Ref planning application No 3/2022/1187

I am writing with concern over the access to the proposed application 3/2022/1187

**Land off Blackburn Road, Longridge – Site Layout Plan 2**

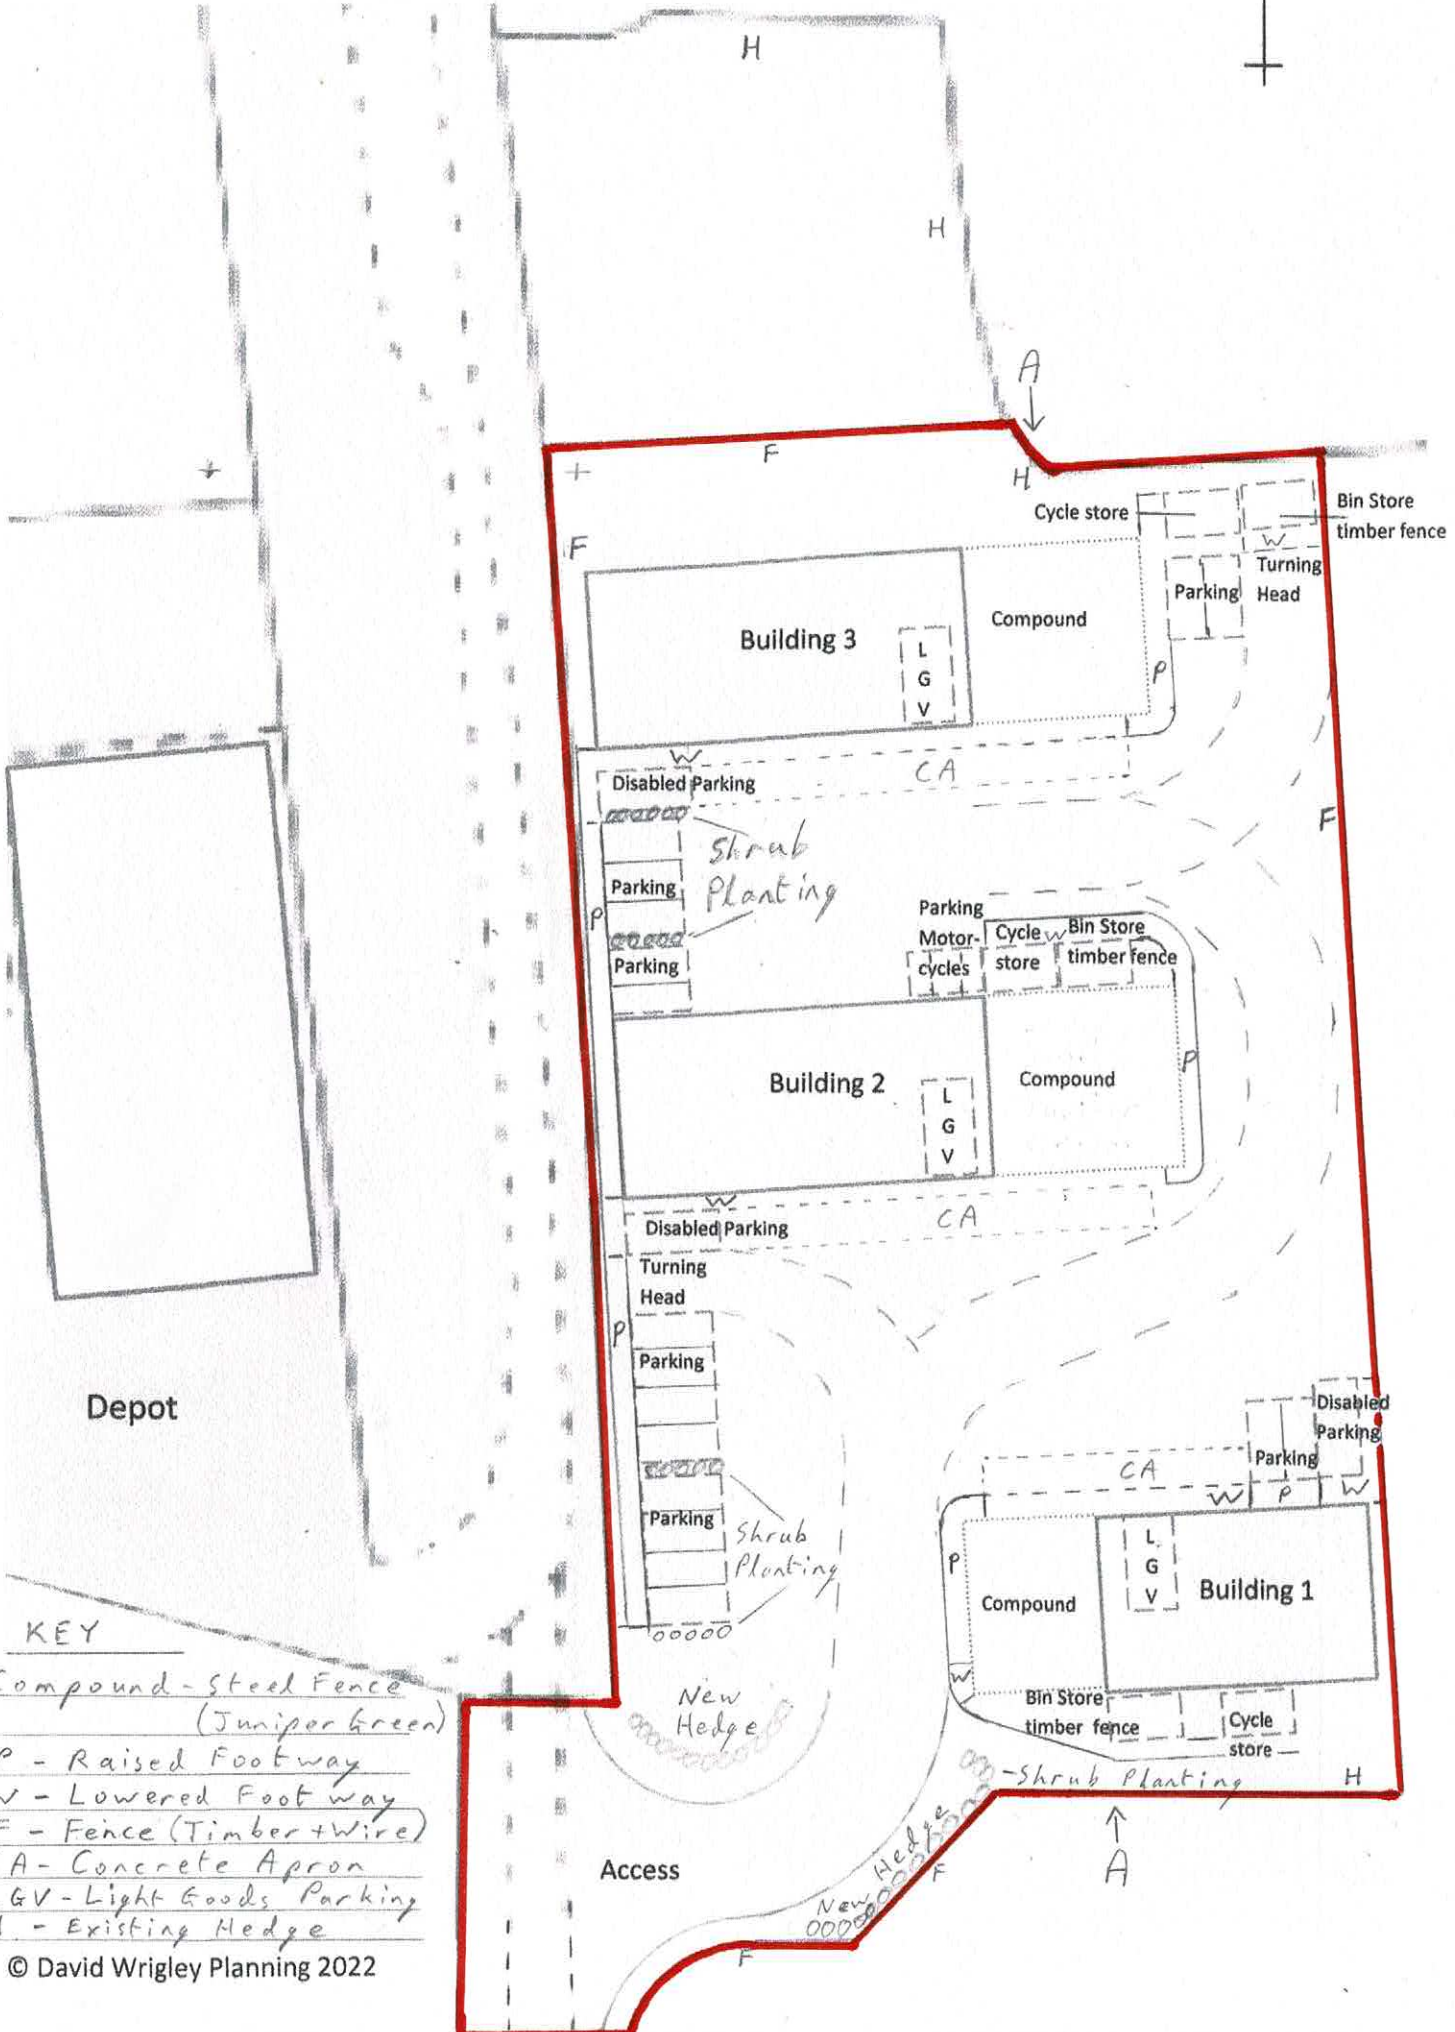
This road [redacted] and [redacted] To service a further three industrial units will create a potential bottle neck on the corner (see drawing).

There is currently a gate by which [redacted] gain access to their property which is locked. Additionally there does not appear to be enough land included in the application to continue the road to access their land.
